**WELWYN HATFIELD COUNCIL – DEVELOPMENT CONTROL**  
**DELEGATED REPORT**

<b>APPLICATION No:</b>	<b>S6/2010/1359/MA</b>
------------------------	------------------------

The proposed development would involve alterations to the site layout to allow additional tractor (lorry) parking spaces. The main alterations would be made to the south western corner of the site where that partly provides 12 tractor spaces and landscaping would be altered to provide 24 trailer spaces.

Dash Dot Architecture Ltd The Loft, 31 Townsend Road, London, N15 4NT t: 07966 301 381 e: m_j_young2000@yahoo.co.uk			
	PROJECT	CLIENT	DATE
	DHL Hatfield	DHL	May 10
	DRAWING	SCALE	DRAWING NO
	Proposed Yard Layout	1:1000 / 250 @ A3	(90)06
			REV
			A

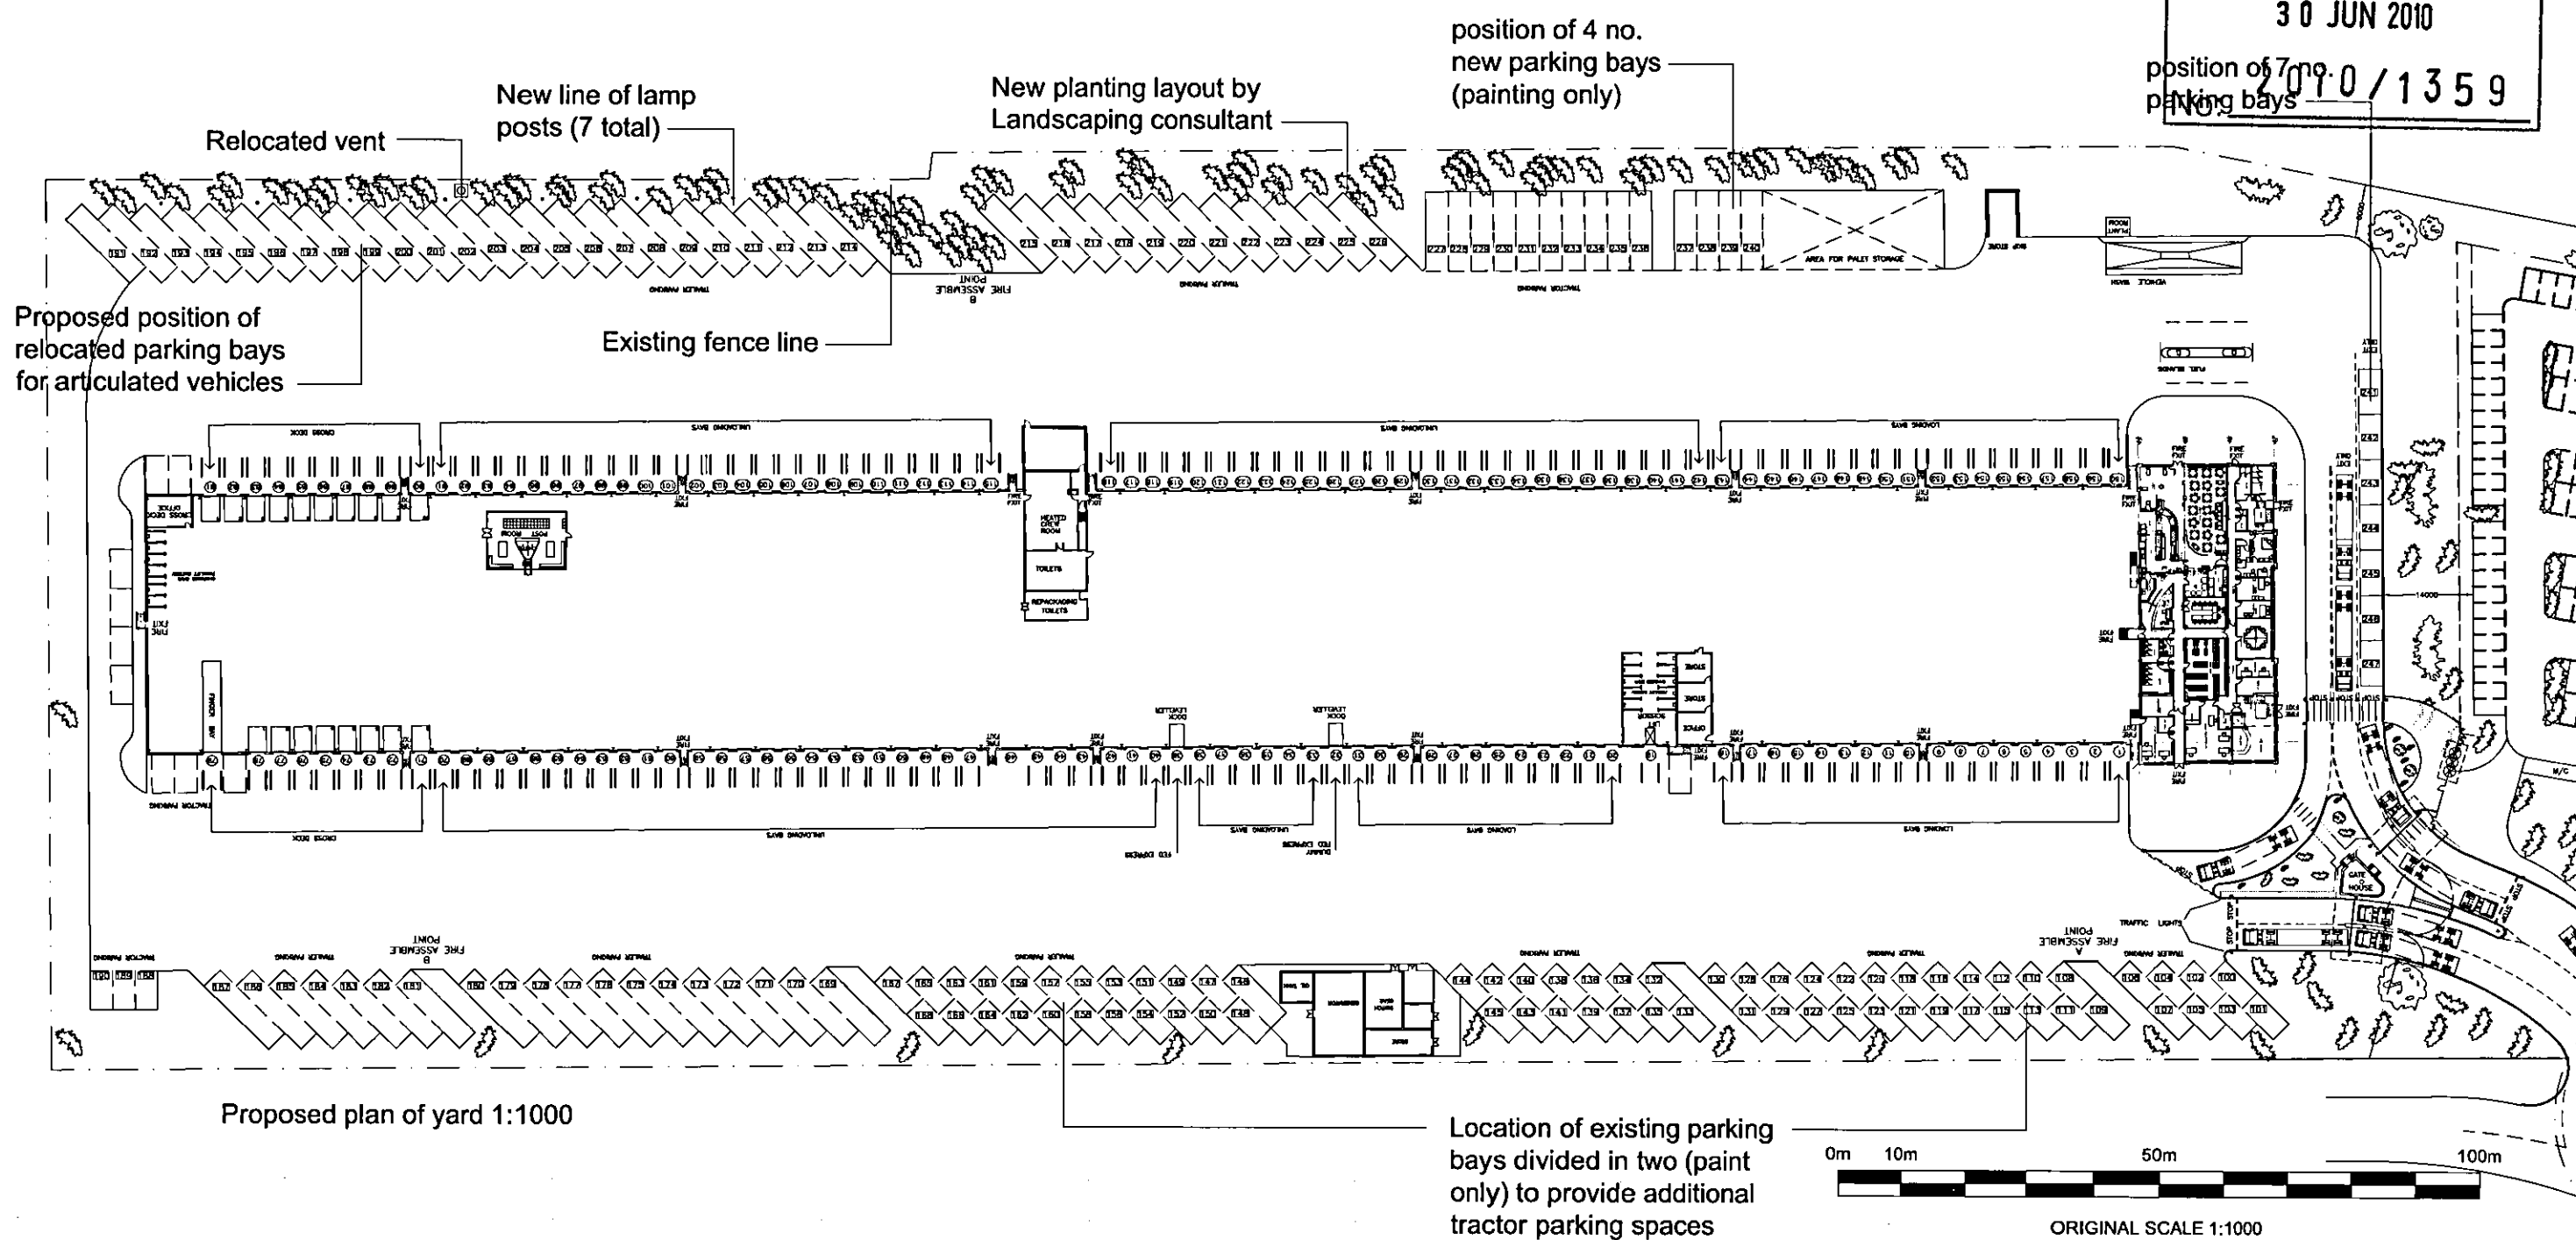
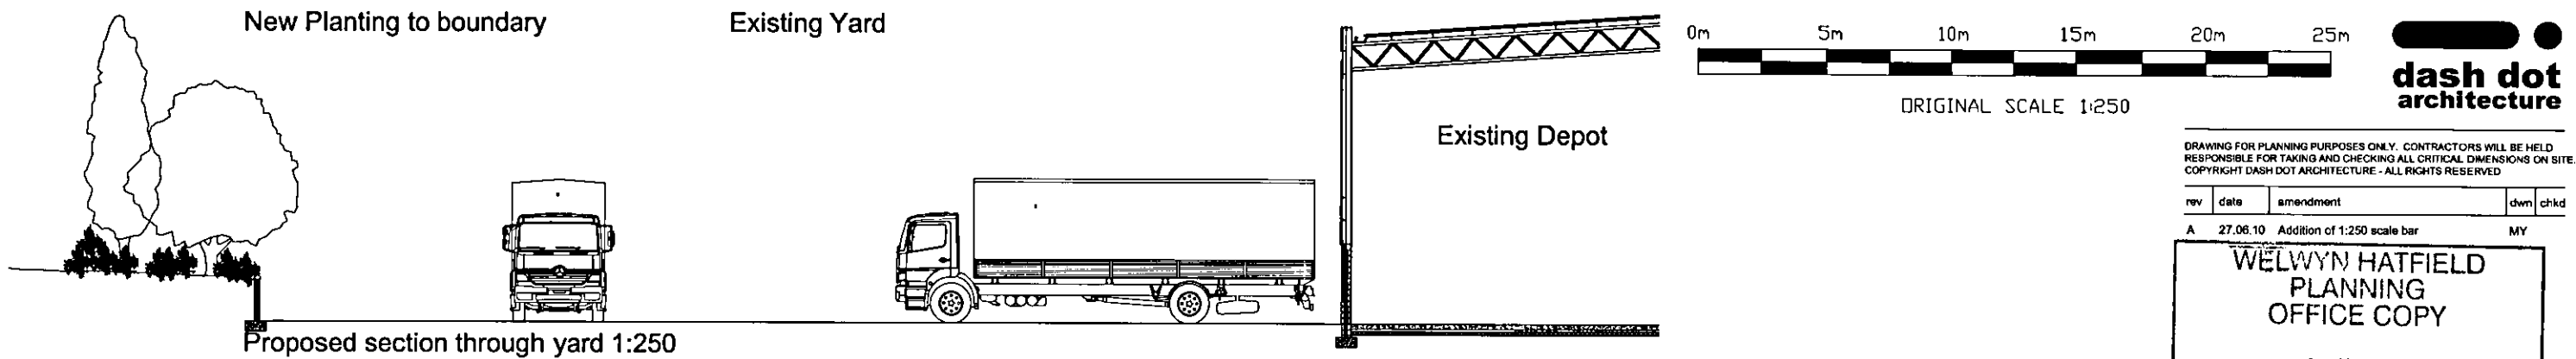
The proposal involves realigning the lighting within the site. As existing there are column lights within this area of the site and the positioning would not be significantly closer to the residential properties. Provided the proposed lighting does not exceed the height and intensity of the existing lighting, if appropriately positioned to focus into the site, the new lighting arrangement would not have an adverse impact upon the residential amenity of the adjoining occupiers.

3. The proposed lighting shall not exceed the height of the existing columns and shall be positioned to focus light within the site and prevent overspill to neighbouring residential area.

1984/3A

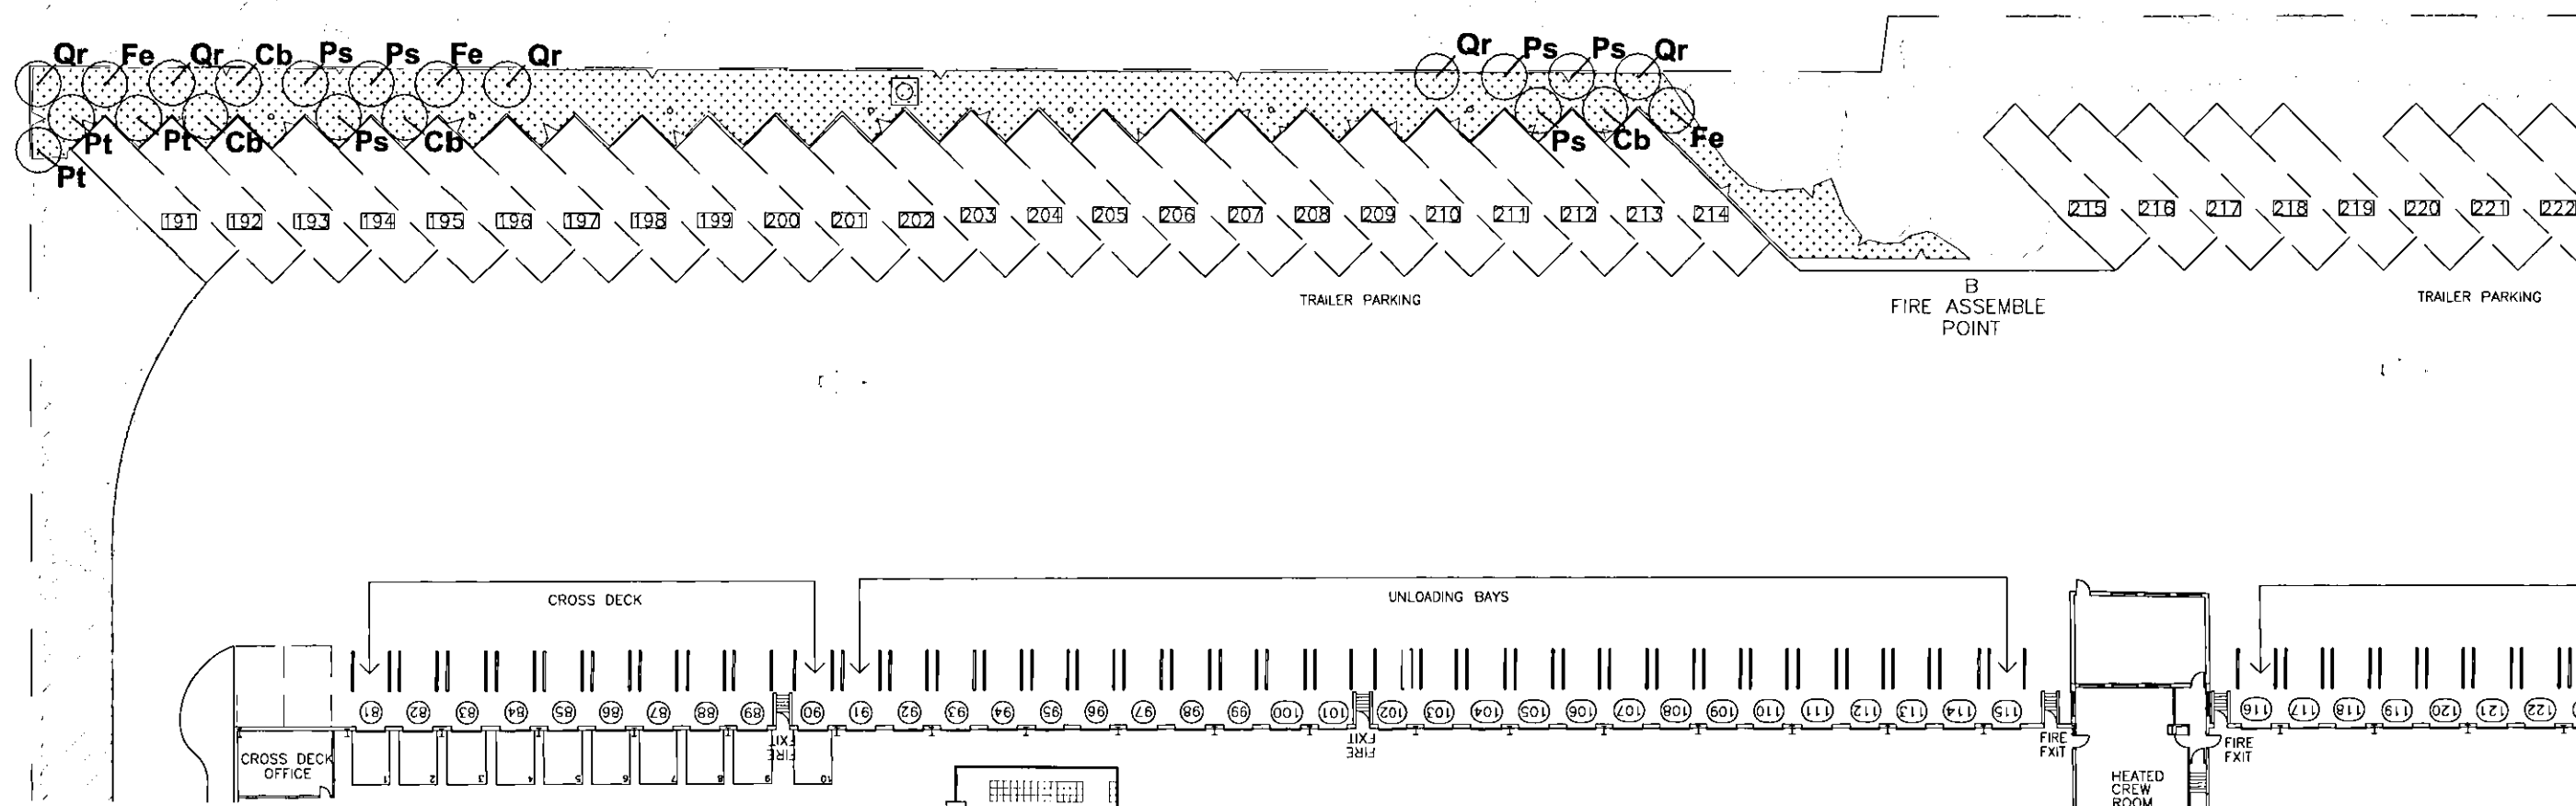
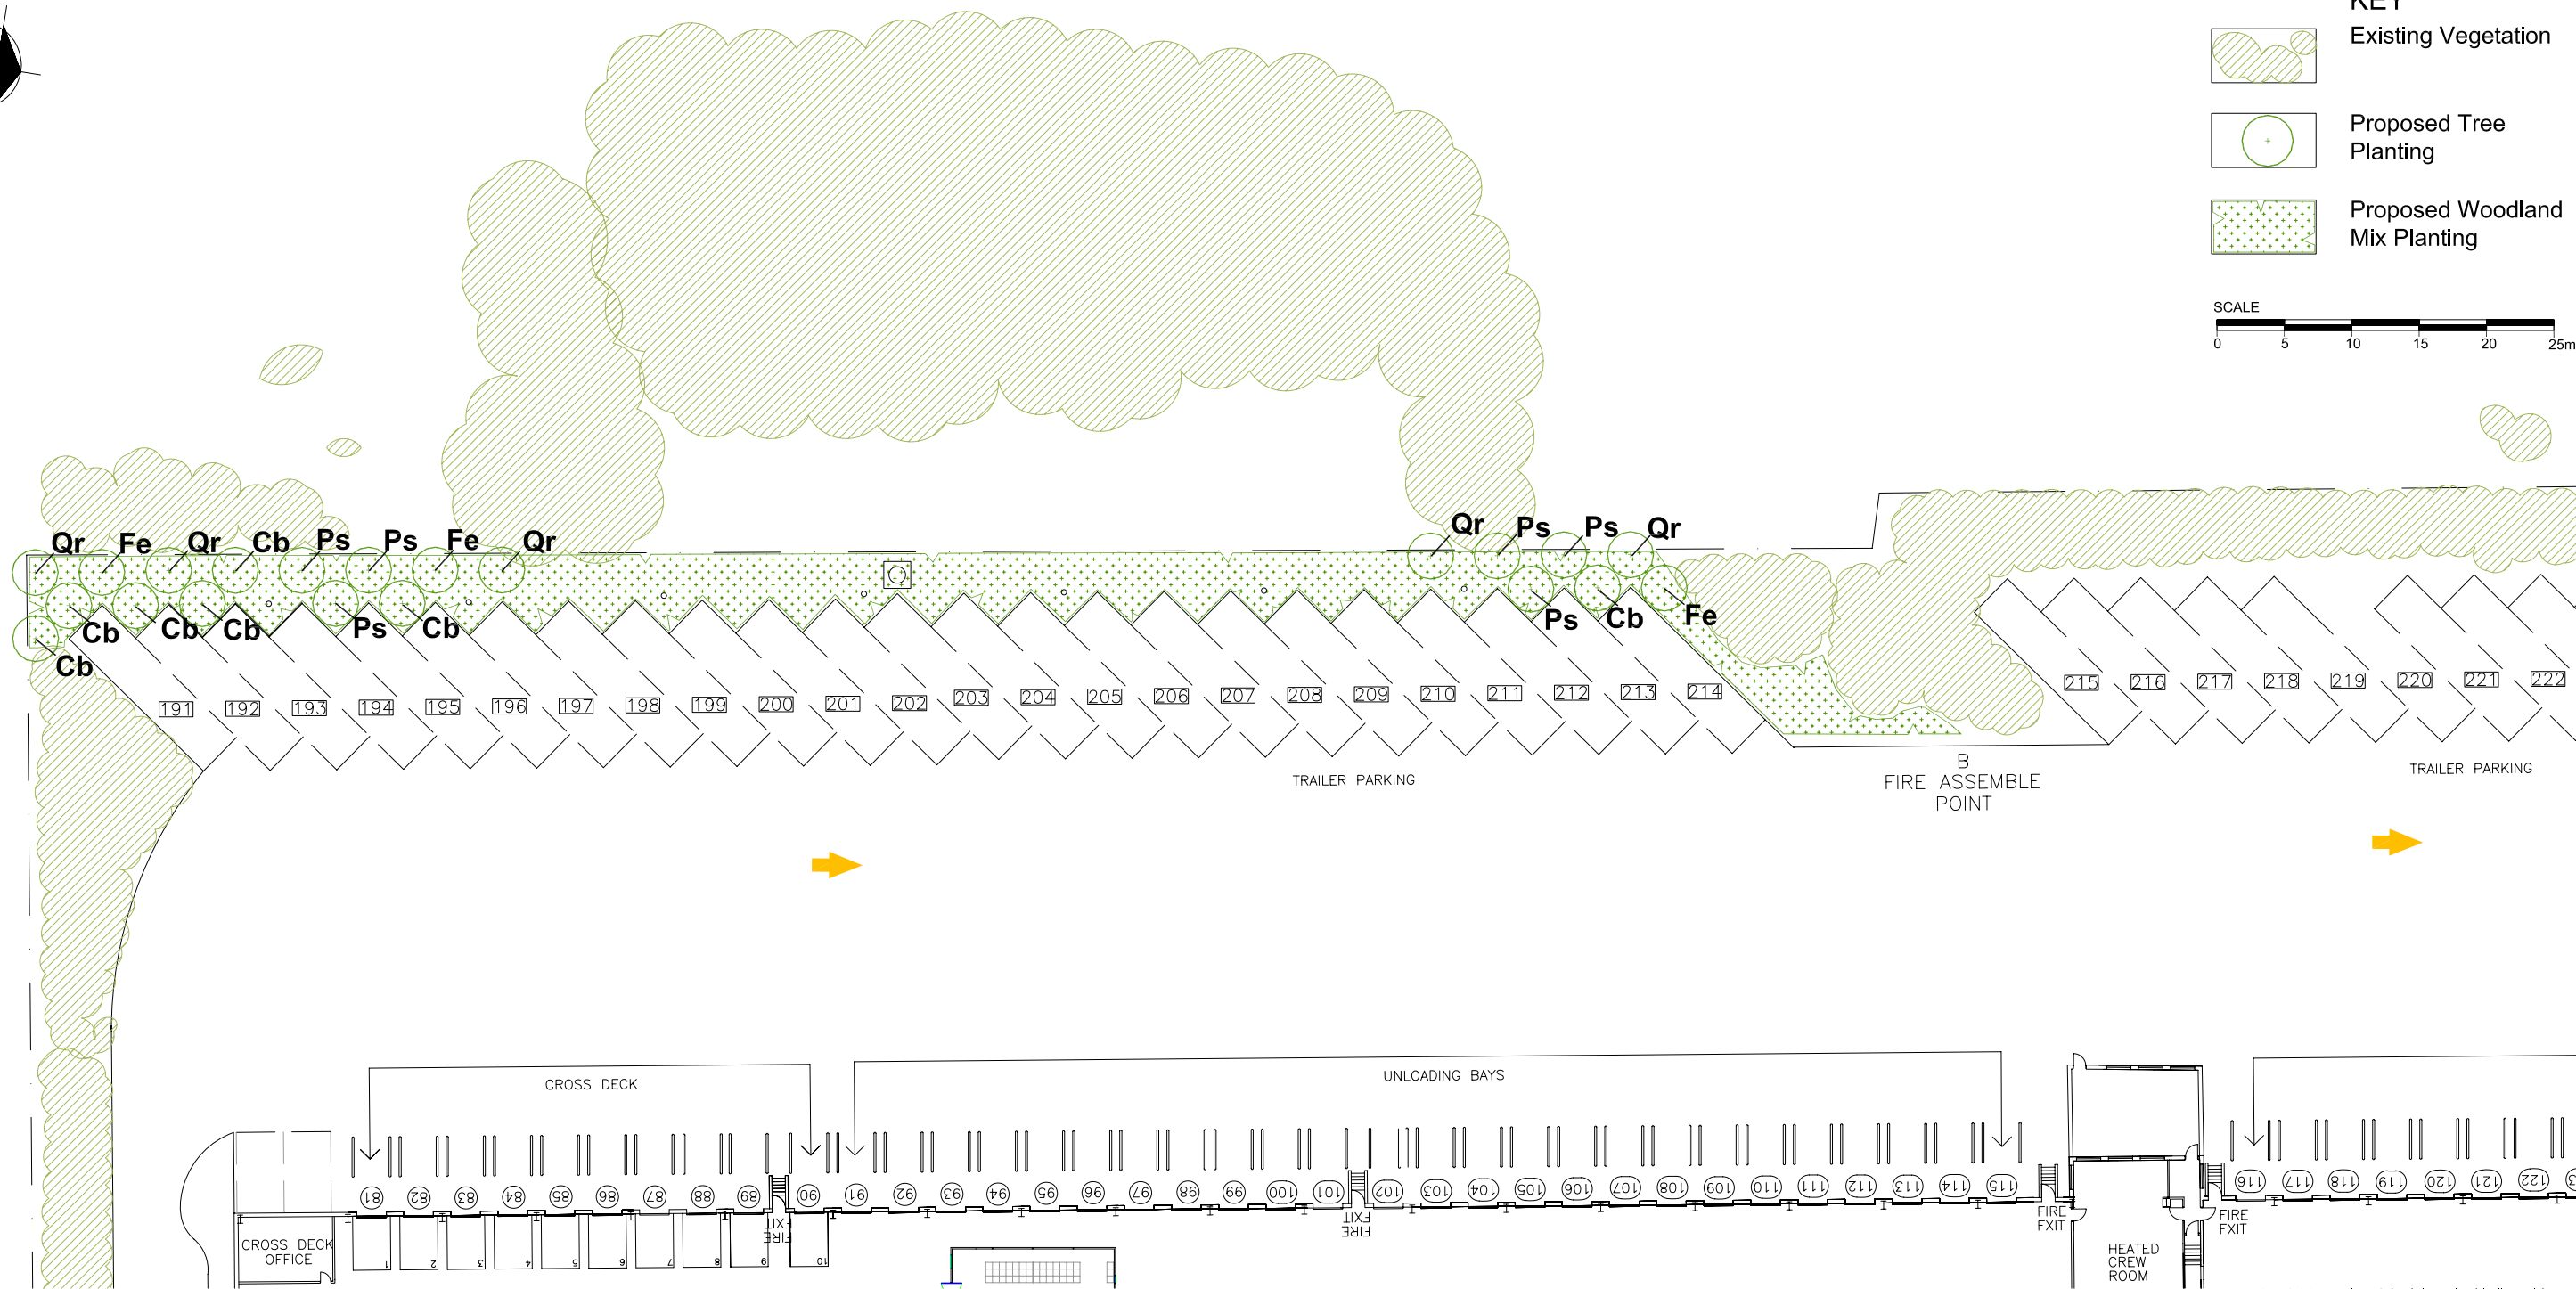
The maintenance plan included with the application is reasonable and includes the points that the Council's Landscape Officer would expect to see. A few small changes to the schedule were suggested. Aspen is listed in the proposed trees, but this would be discouraged and it has been suggested to plant three more hornbeam. Within the woodland mix are privet and goat willow, which would also be discouraged. The quantity of privet can be split between thorn and field maple and the number of goat willow should be added to hornbeam.

The suggested amendments take account of which species thrive in this area and appropriate species that will tolerate pruning, as this may be necessary if the trees either obscure the lamp columns, CCTV or overhand the parking spaces.

The amendments were incorporated into the landscaping proposals and an amended plan was submitted. The amended planting plan is considered to be acceptable and meets the requirements of Policy D8 of the Welwyn Hatfield District Plan 2005.
